# HERBATA DATA CENTRE, NAAS - RESPONSE TO REQUEST FOR FURTHER INFORMATION ("RESPONSE TO RFI") FROM KILDARE COUNTY COUNCIL

## ADDENDUM TO CHAPTER 5 BIODIVERSITY

NI2615  
01  
June 2025

3 A1400 - TIMBER POST AND WIRE FENCING
1 : 10

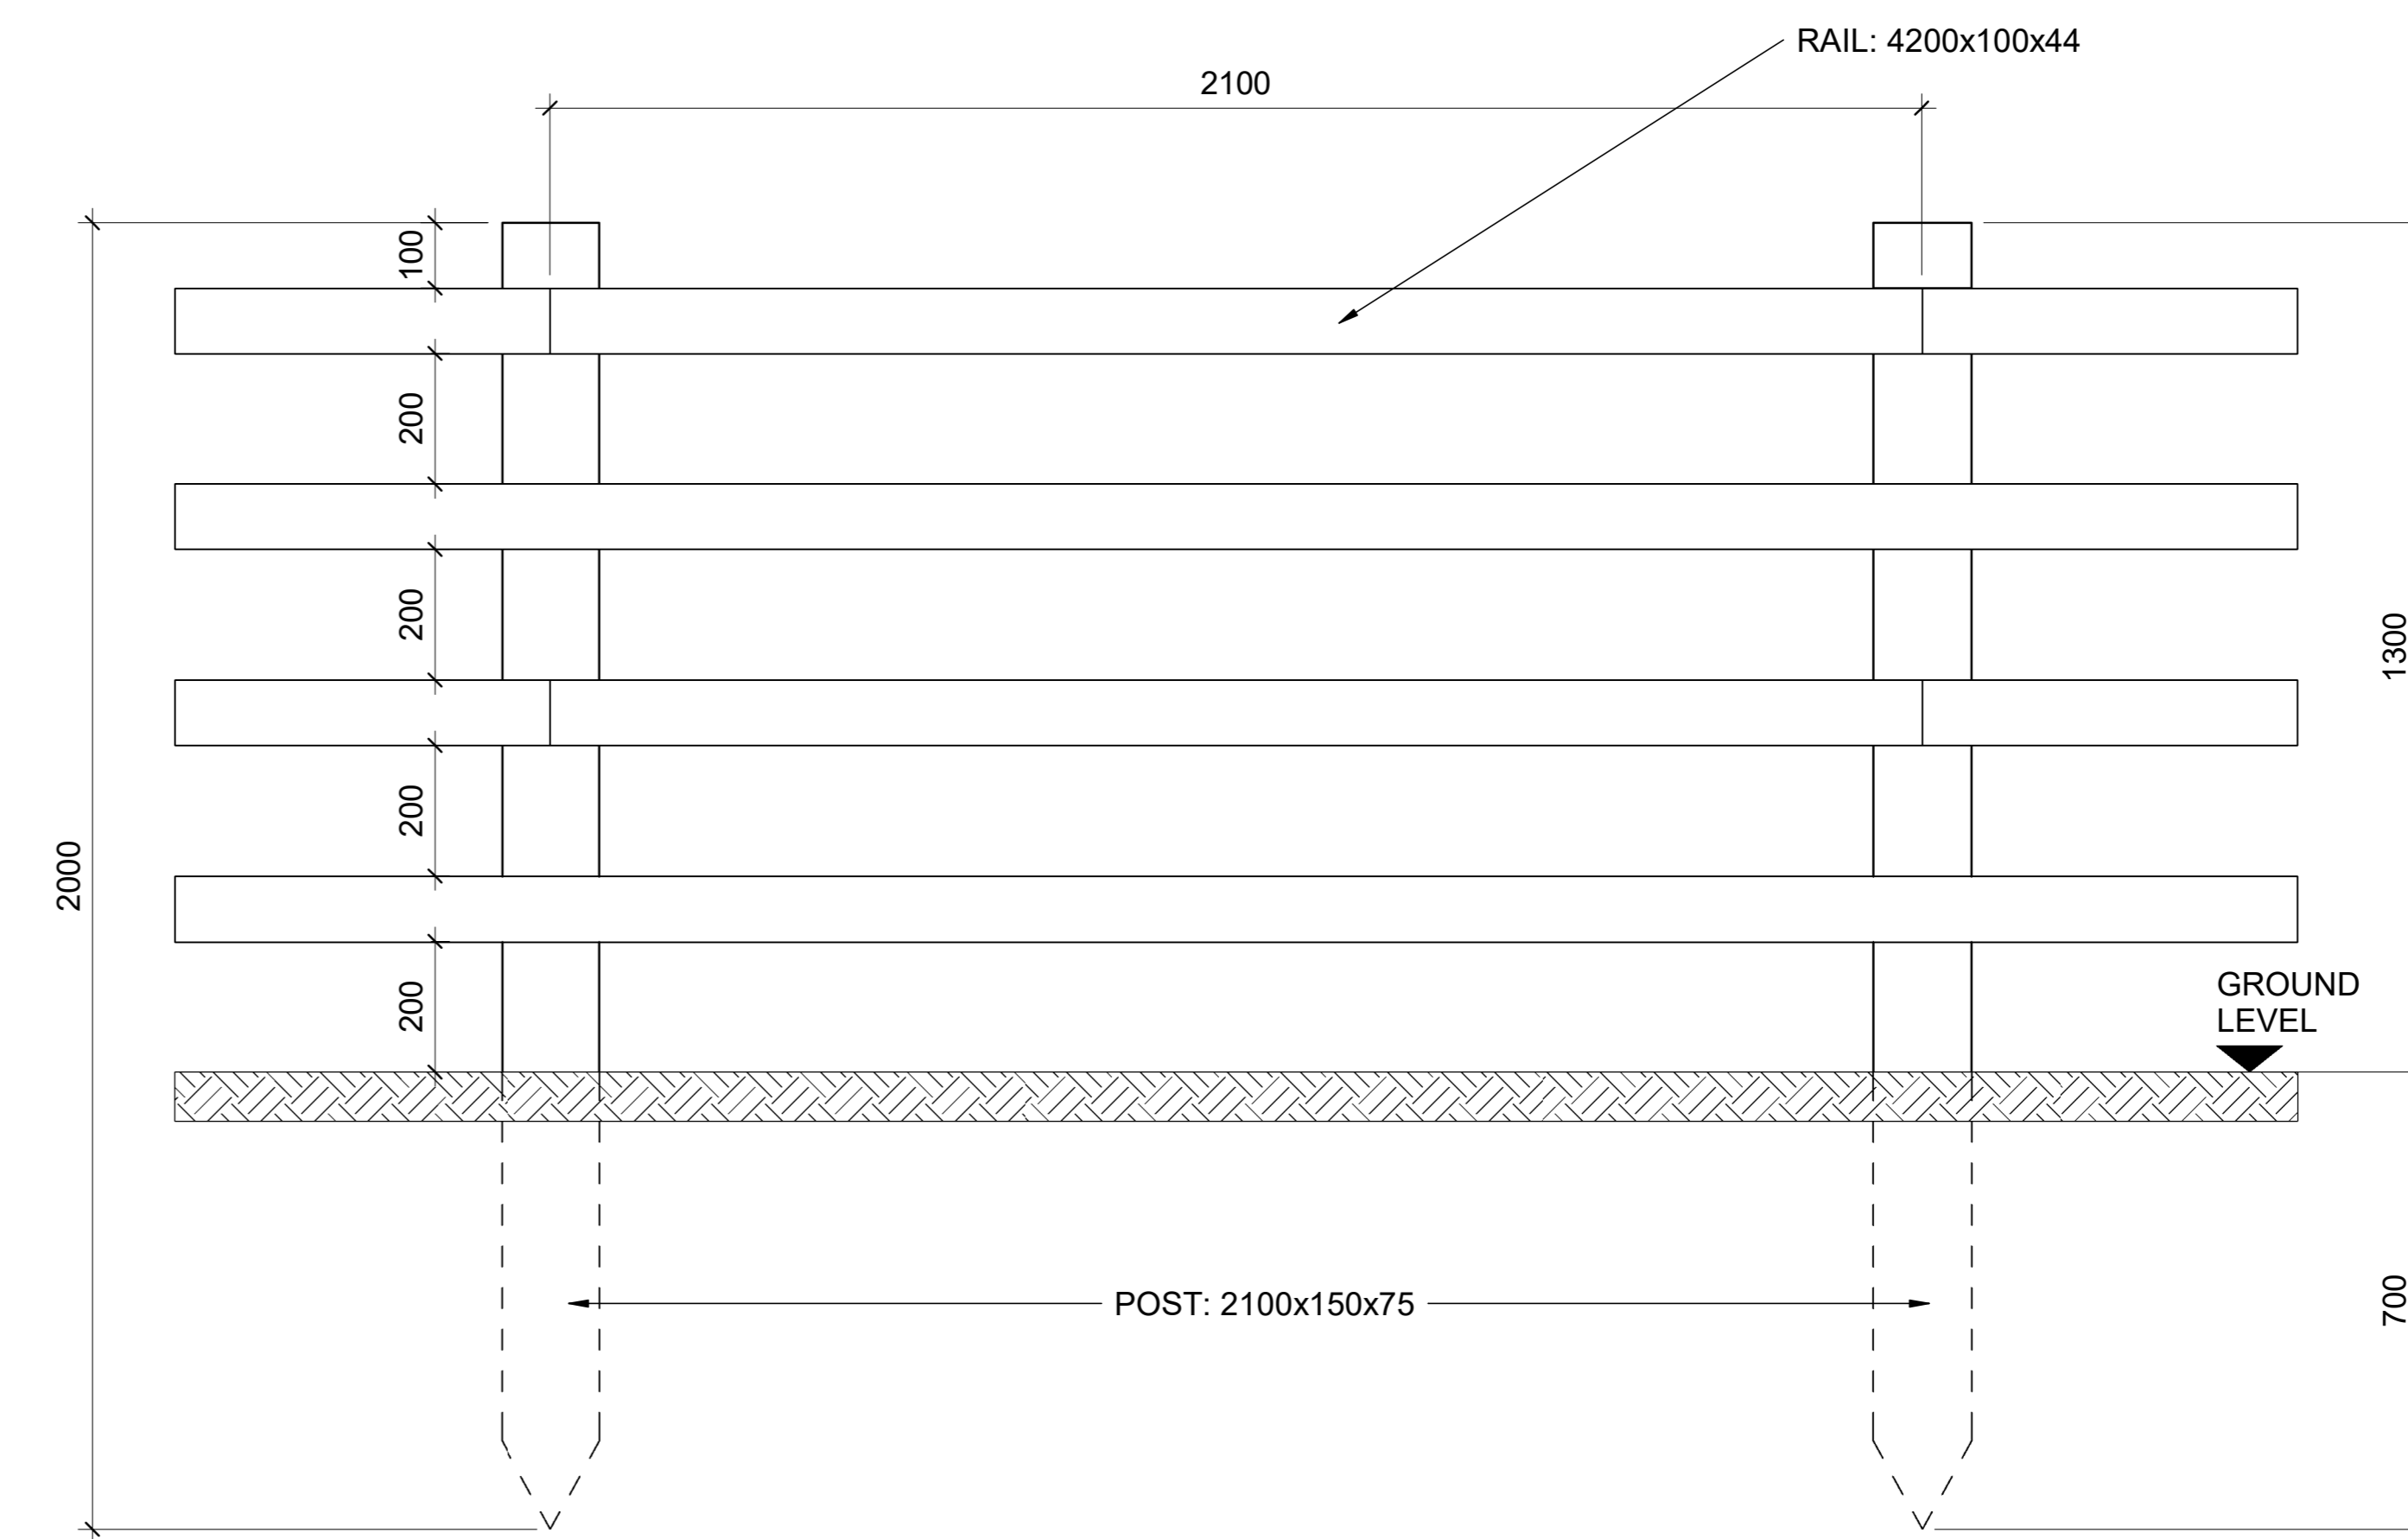
The post and rail fencing (around the proposed ponds and to the frontage of the site on to the R409), as proposed in the submitted planning application, incorporates a gap of 200mm (height) at the foot of the fencing, providing sufficient clearance for all potential mammal species to ensure access and passage throughout the site. There is therefore no change proposed to these fencing arrangements in light of Item 6 of the Kildare County Council RFI.

Figure 5.3 below (extract of drawing number 22217-RKD-ZZ-ZZ-DR-A-1400 Proposed Boundary and Fence Details) illustrates the detailed dimensions of the fencing. It should be noted, this fence design was proposed as part of the submitted design package and this design has not been changed as part of the amended design; the drawing extract below has been provided for completeness.
